CITY OF ALBUQUERQUE

April 28, 2017

**Re: Eagle Ranch NM MVD
Erosion and Sediment Control Plan
Engineer's Stamp Date 4-3-17 (B13E002C)**

Inspections Plus Inc.  
Erosion Control Plan  
Standard Details

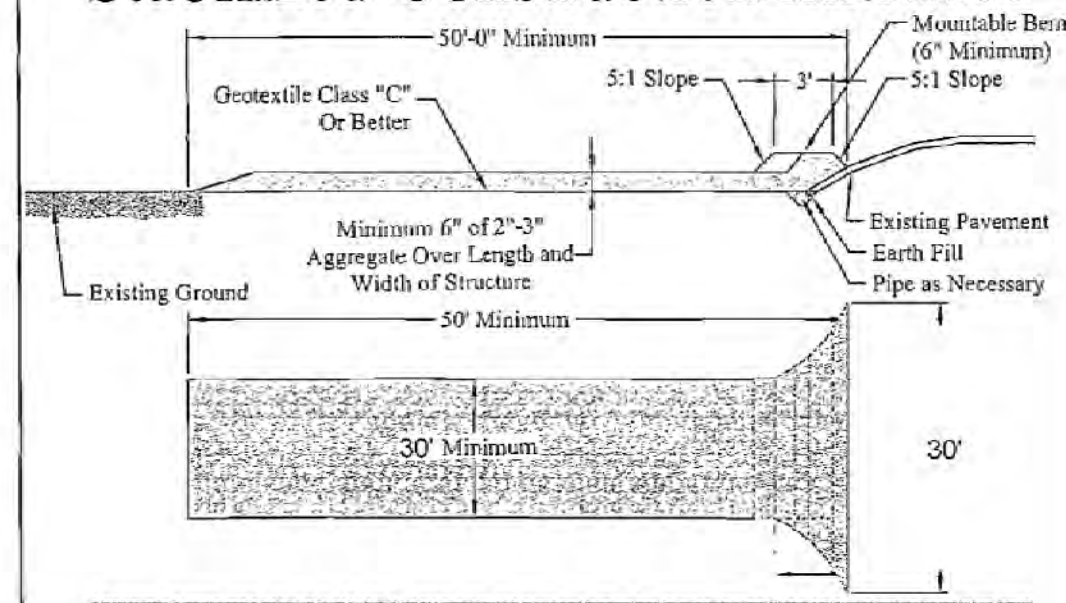
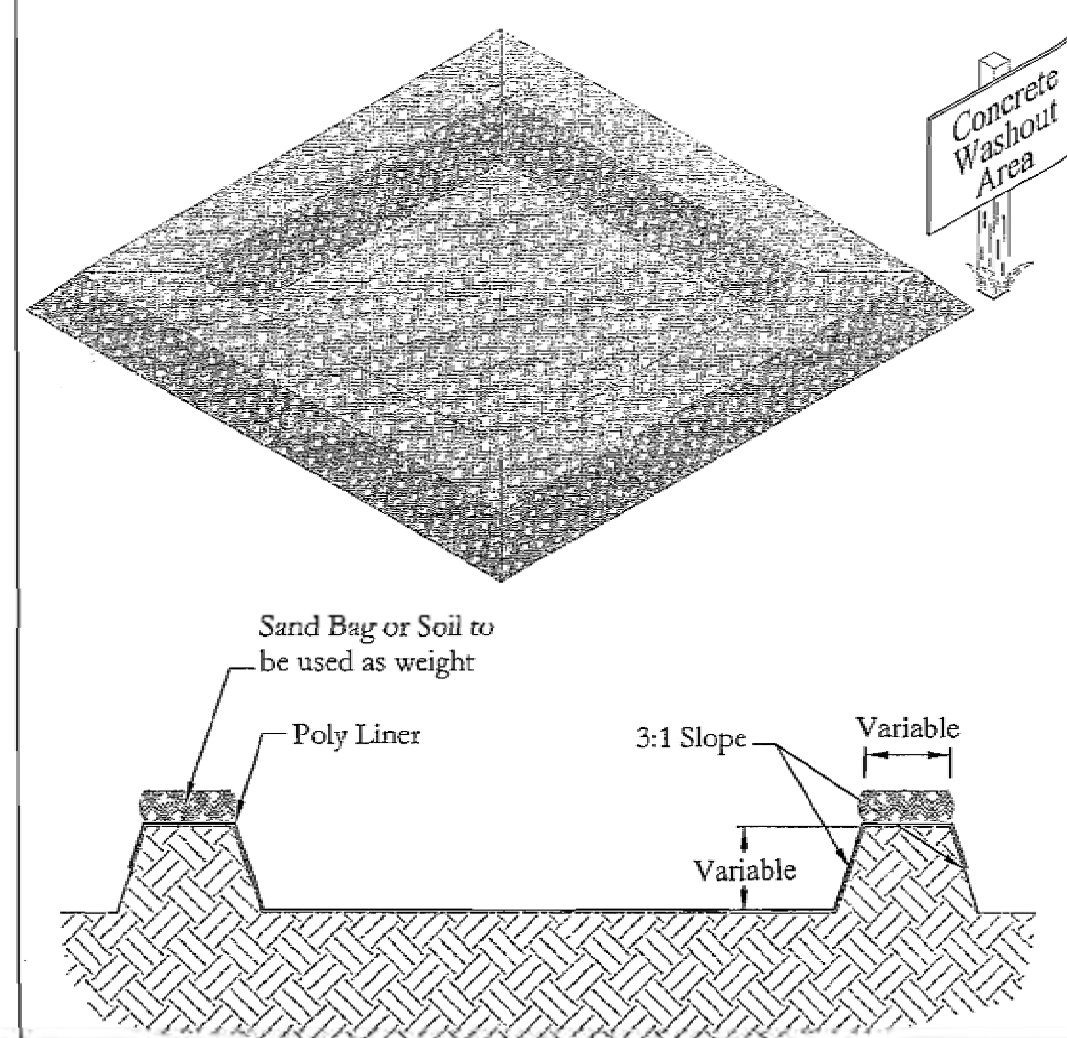
1. The plan shows proposed grades for the area between the NM MVD and Eagle Ranch Road, yet there are no BMPs for the grading. The plan shows a retaining wall, but a sediment BMP is required for construction of the wall and the grading.

2. An inlet is shown in the northeast corner of the site next to Eagle Ranch Road. Provide inlet protection.
3. There is a tall retaining wall separating the east and west halves of this project. Seems a stabilized construction entrance should be provided for each half.

4. The upper drive aisle west of the stabilized construction entrance is steep; 5.7% for 320 feet. A BMP (e.g. berm) should be added to prevent sediment from leaving the site out the stabilized construction entrance.

5. Add a sediment BMP along the northern edge of the east half of the project.
6. The proposed storm drain work is close to Eagle Ranch Road. Please add the note "When doing work in the City ROW (e.g. sidewalk, drive pads, utilities, etc...) prevent dirt from getting into the street. If dirt is present in the street, the street should be swept at the end of each day or during the day if rain is imminent or if the contractor induces water into the street."
